# CITY OF ALBUQUERQUE

RE: **Parking Lot for 6<sup>th</sup> St/Fruit Ave**  
**6th St/Fruit Ave**  
**Grading and Drainage Plan**  
**Engineers Stamp Date 8/4/15 (J14D177)**

Based upon the information provided in your submittal received 8/4/15, this plan cannot be approved for Grading Permit or Paving Permit until the following comments are addressed.

ENGINEER'S SEAL 8/4/15 DAVID SOULE P.E. #14522	PARKING LOT FOR 6TH ST AND FRUIT AVE. GRADING AND DRAINAGE PLAN Rio Grande Engineering 1808 CENTRAL AVENUE SUITE 201 ALBUQUERQUE, NM 87106 (505) 872-0888	DRAWN BY DEM
		DATE 7-15-15
		SHEET # 2 of 3
		JOB # XXXXX

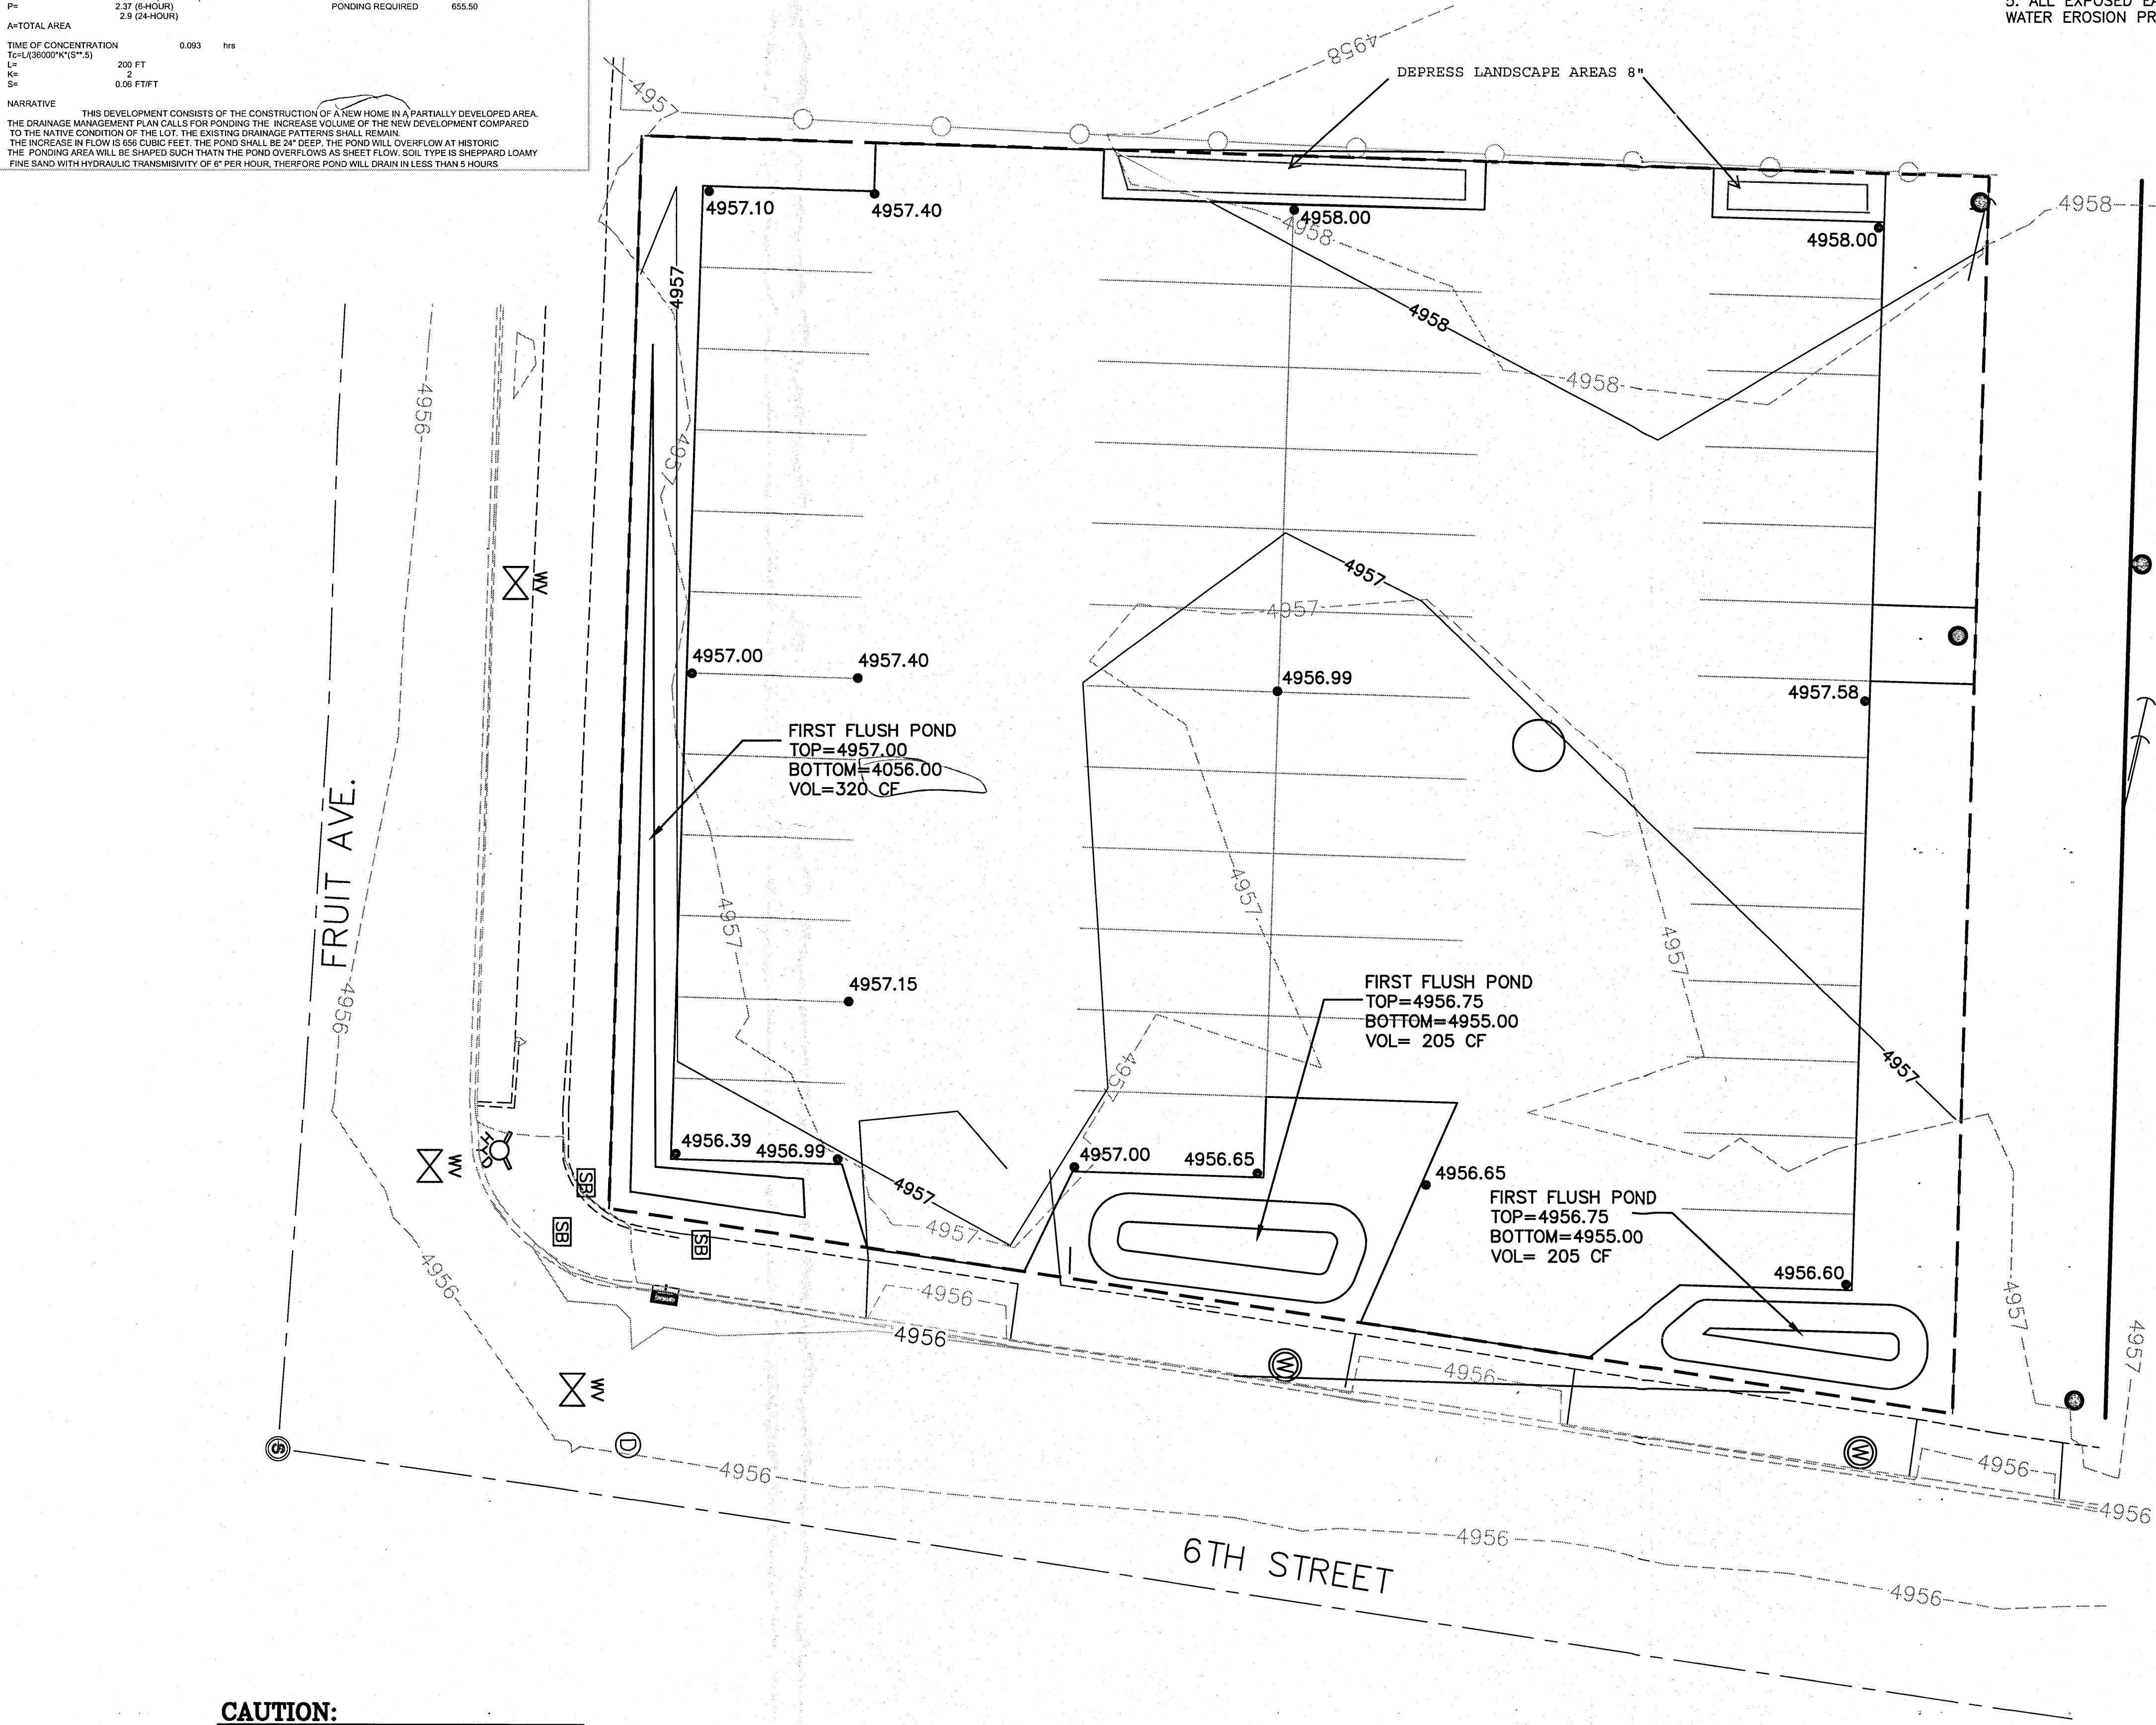
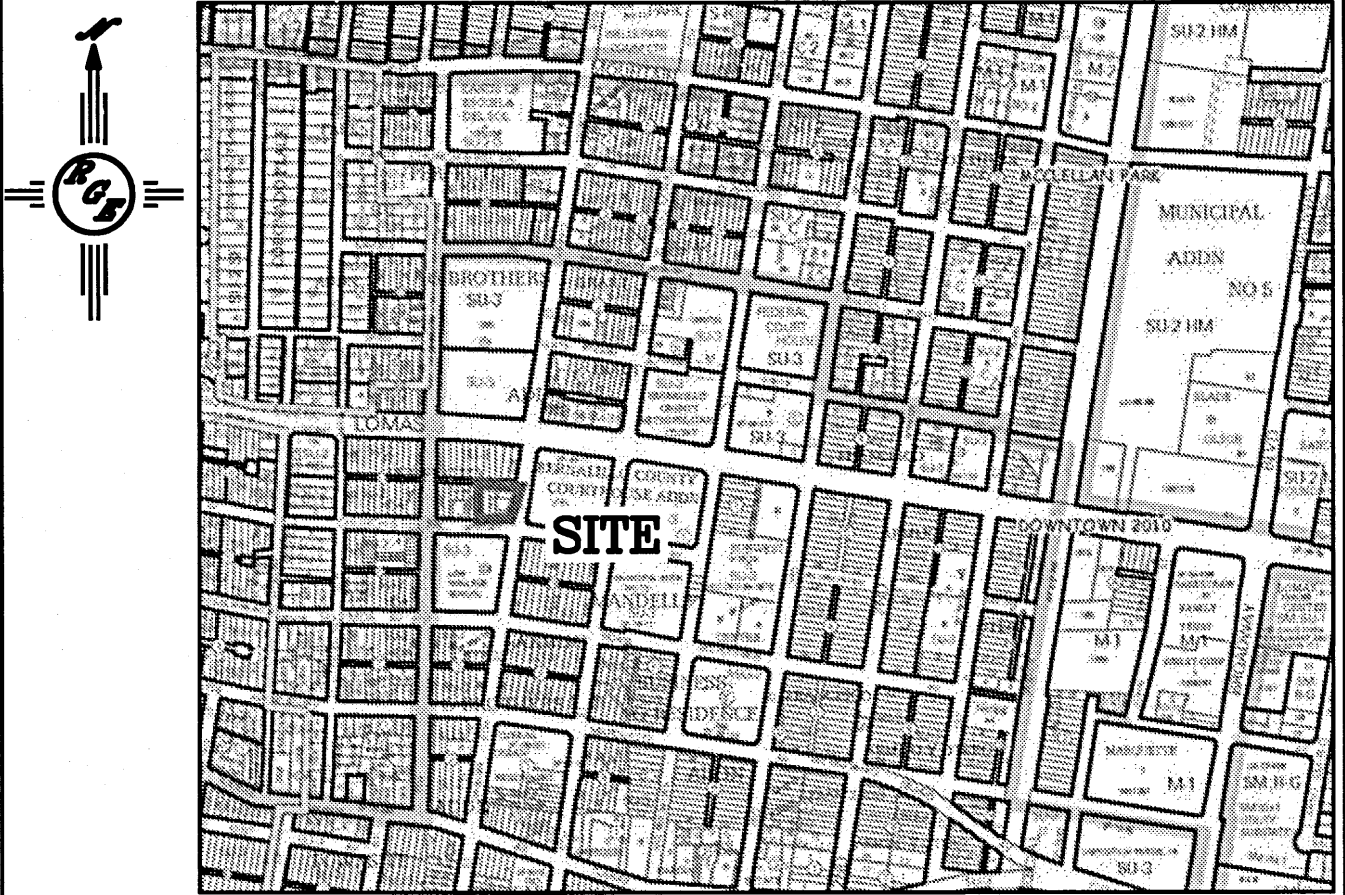
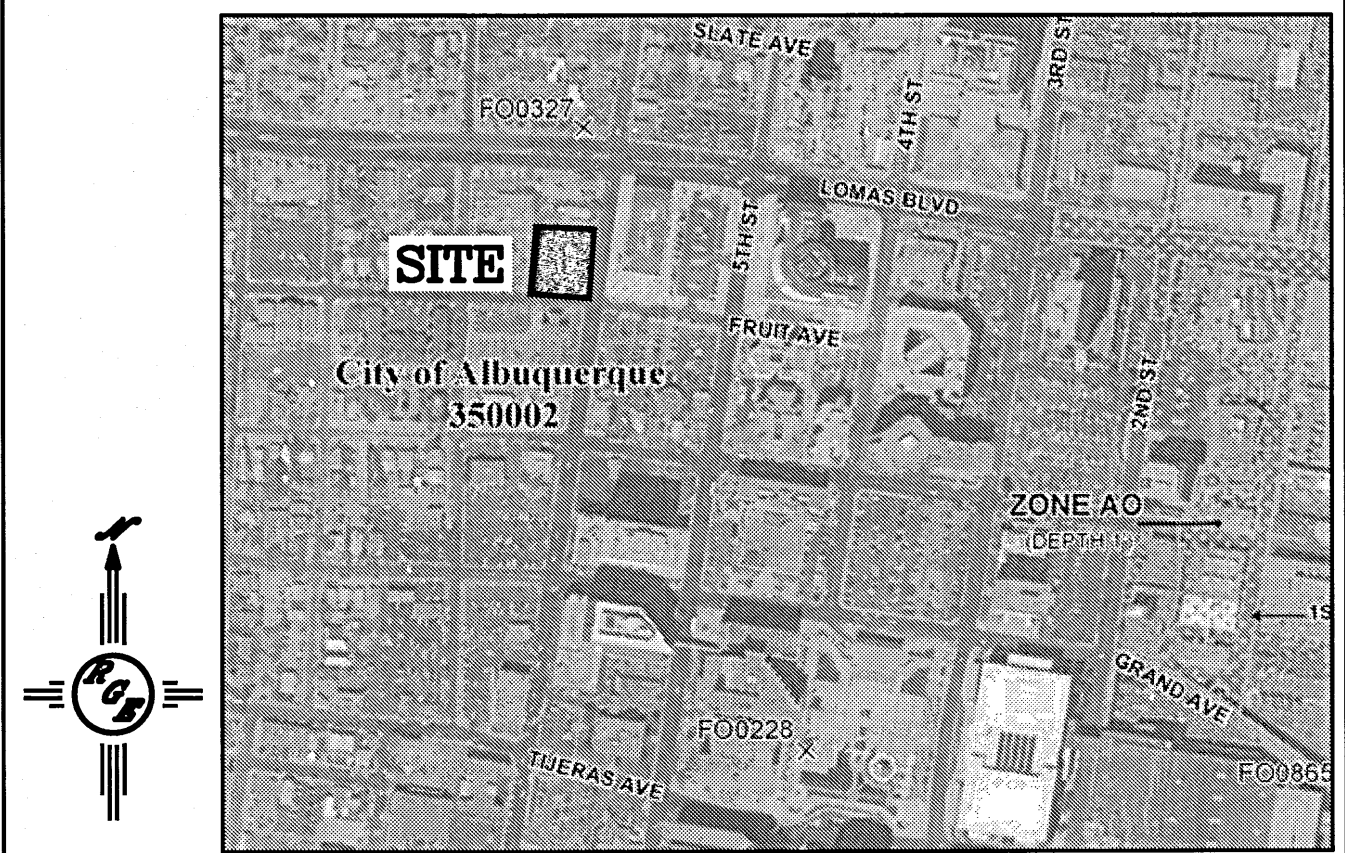
- Provide a larger font for the Drainage Calculation Sheet. *Not complete*
- In the narrative a new home being built is mentioned. Where is the home located in this parking lot? *Not answered*
- The first flush pond to the south shows a TOP = 4957.00 and a BOTTOM = 4056.00, I hope this is a typo, adjust accordingly. *Not answered*
- The three ponds to the east have a TOP shown larger than the spot elevation provided next to the ponds, adjust accordingly. *Not answered*
- Is the lot being paved, or kept as is? Are parking bumpers supplied? The alley will need to be paved. A TCL is required. *Not answered*
- Provide the benchmark. *Not answered*
- How will erosion, dirt, dust from the parking lot be kept out of the right of way (6<sup>th</sup> St.)? *Not answered*
